Rezoning Transportation Analysis

Petition Number: 2021-178

General Location Identifier: 07706303

SHEET NUMBER:
RZ-1

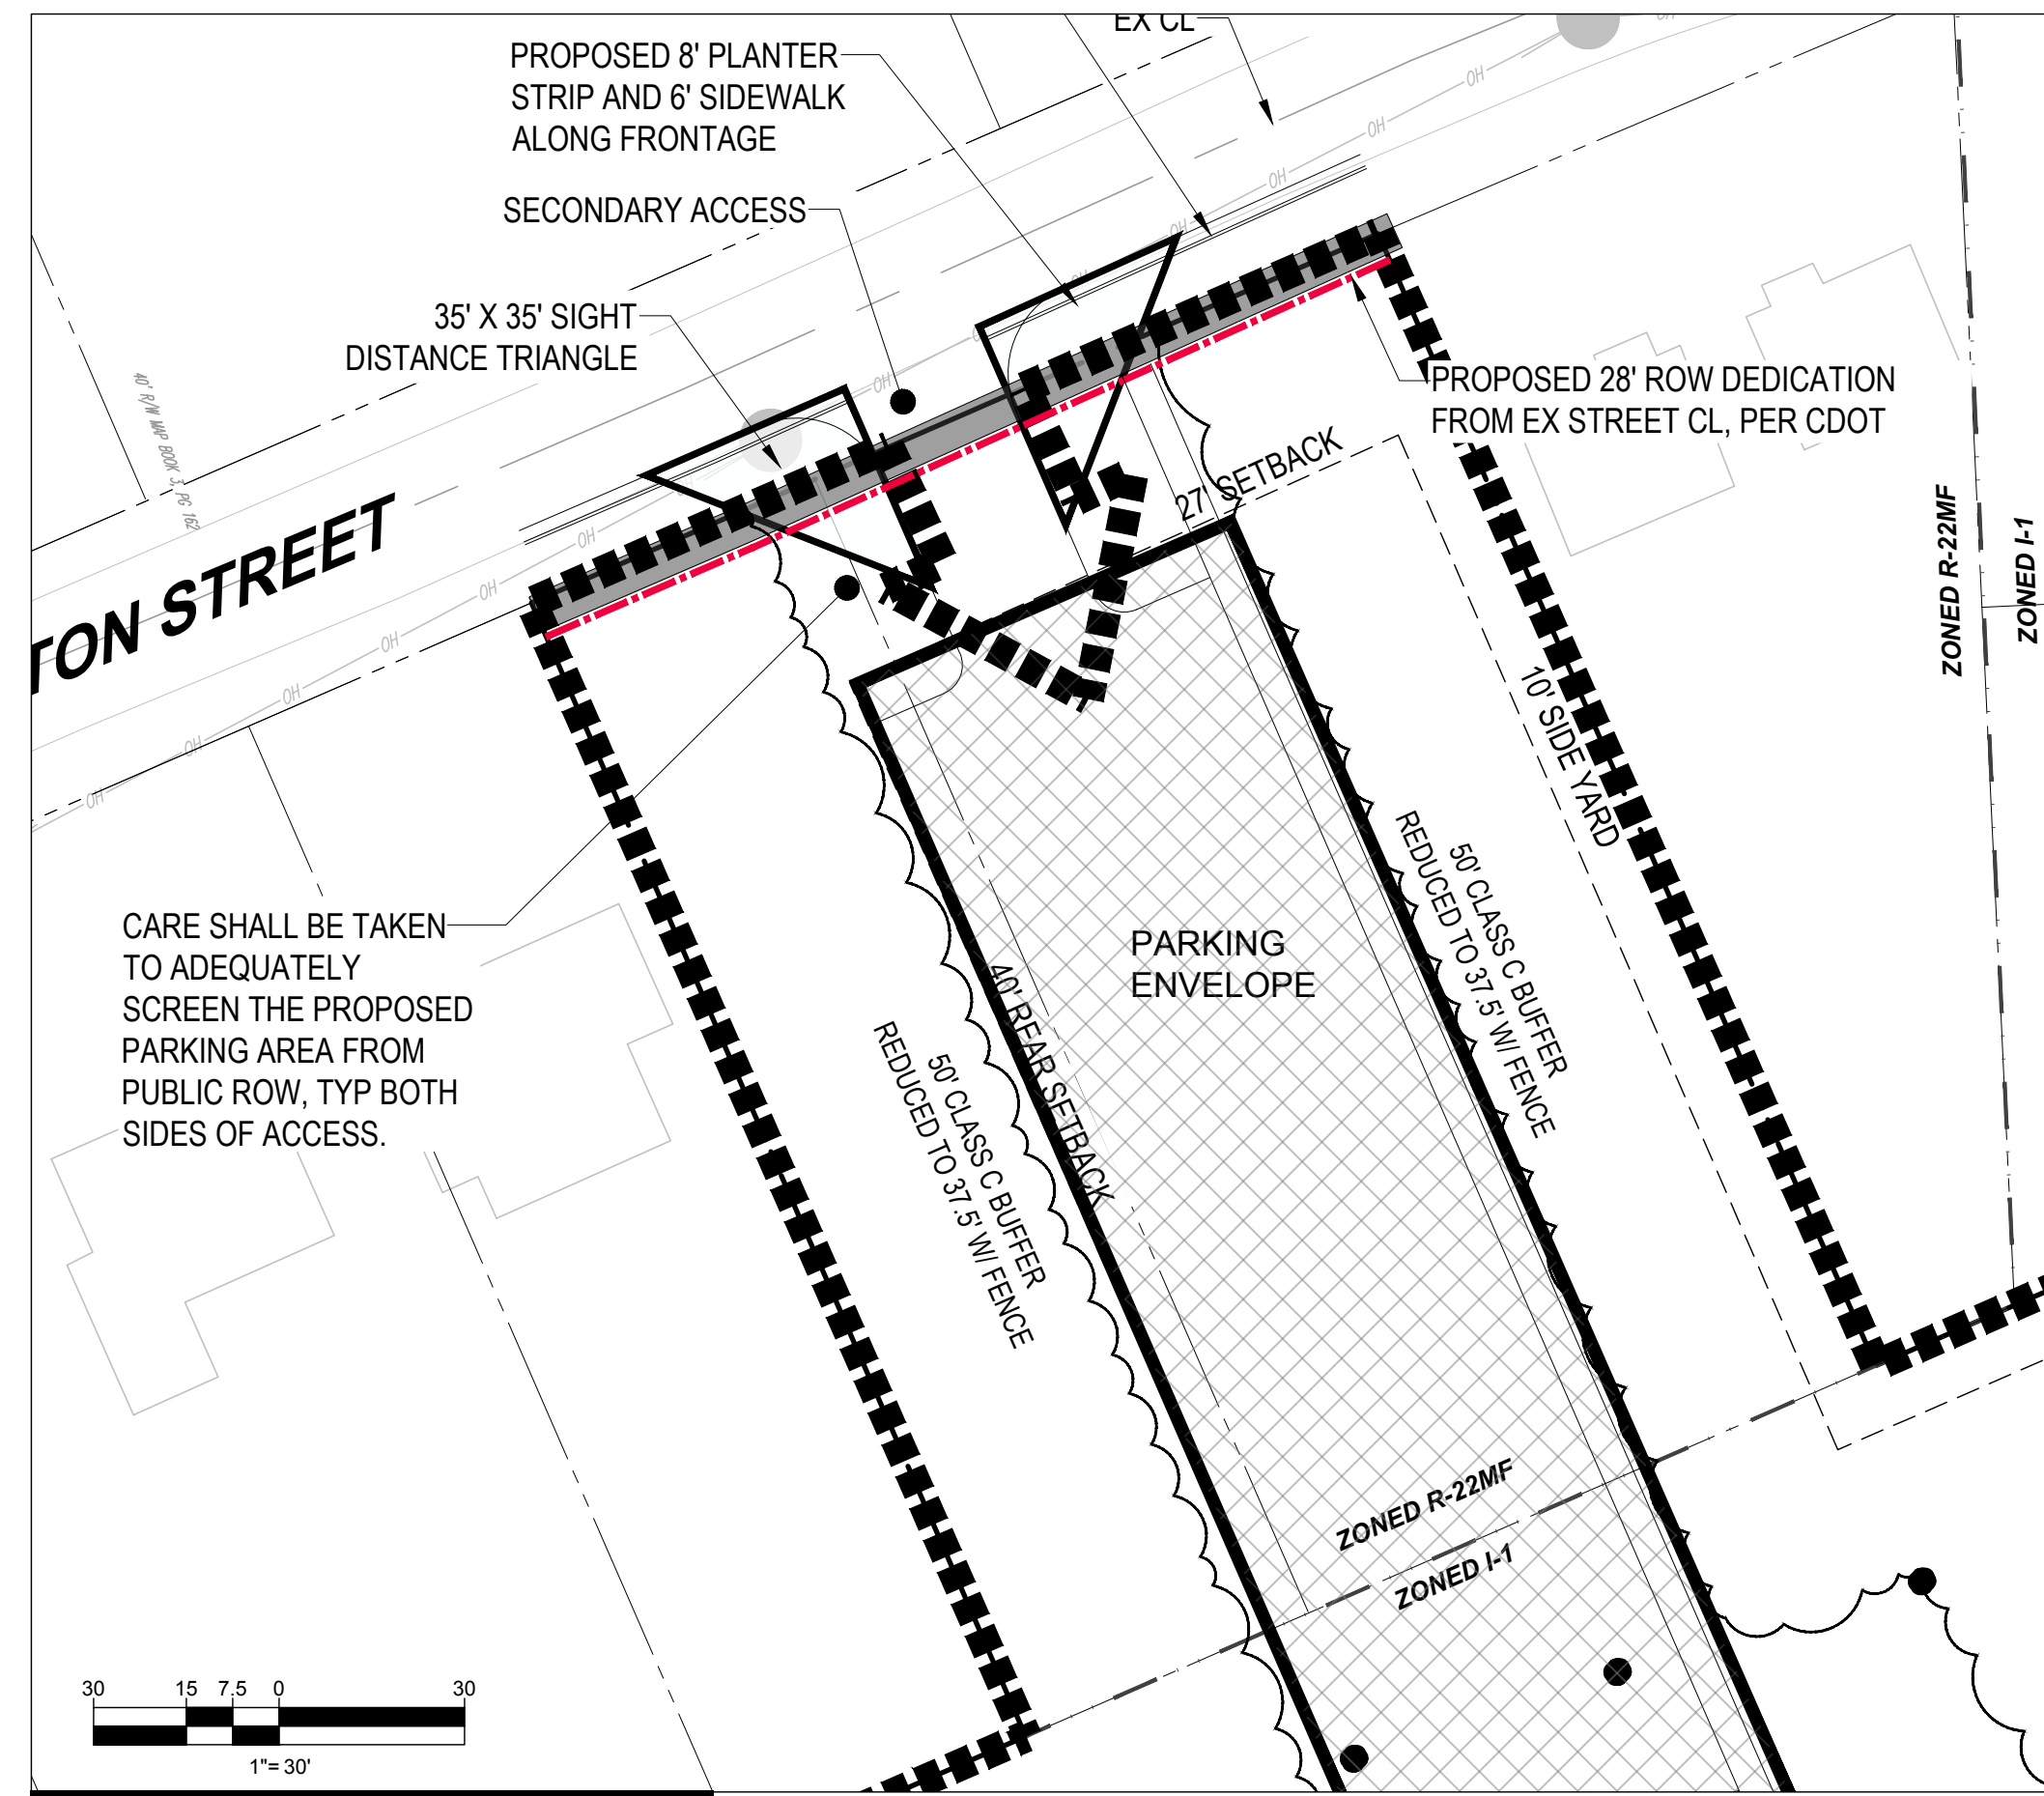
1. **Curblines:** The proposed zoning district has a setback measured from back of the existing or proposed future curblines.
 - a. **Statesville Avenue:** Location of existing curb and gutter is in the future location.
 - b. **Atando Avenue:** Location of existing curb and gutter is in the future location.

Label and dimension the curb and gutter from the centerline for each road on the site plan.

3. Revise site plan and conditional note(s) to commit to dedicate 28 feet of right-of-way from the road centerline of Whittington Street. The site plan shall label and dimension the right-of-way from the road centerline.

4. Revise site plan to label and dimension right-of-way on Statesville Avenue and Atando Avenue.
5. The proposed dwelling units exceeds 12 per acre. Per Chapter 20 Subdivision ordinance, site plan and conditional note(s) revisions are needed to commit to construct an 8-foot planting strip, and 12-foot multi-use path along Statesville Avenue and Atando Avenue. The wider sidewalk also meets the Charlotte WALKS Policy and Charlotte BIKES Policies.

9. Revise site plan to install curb and gutter along property frontage of Whittington Street per Chapter 19 and Chapter 20. Refer to CLDSM U-02 for Local Residential Medium Street cross-section.

10. Revise site plan and conditional note(s) to commit to construct an 8-foot planting strip, and 6-foot sidewalk on Whittington Street per Chapter 19. The site plan shall label and dimension both items from the back of curb and gutter and road centerline.
11. Revise site plan and conditional note(s) to commit to installing a local residential median street per CLDSM U-02 (**Request**) or a 12-foot multi-use path (**Required**) connecting Whittington Street to Julia Avenue.
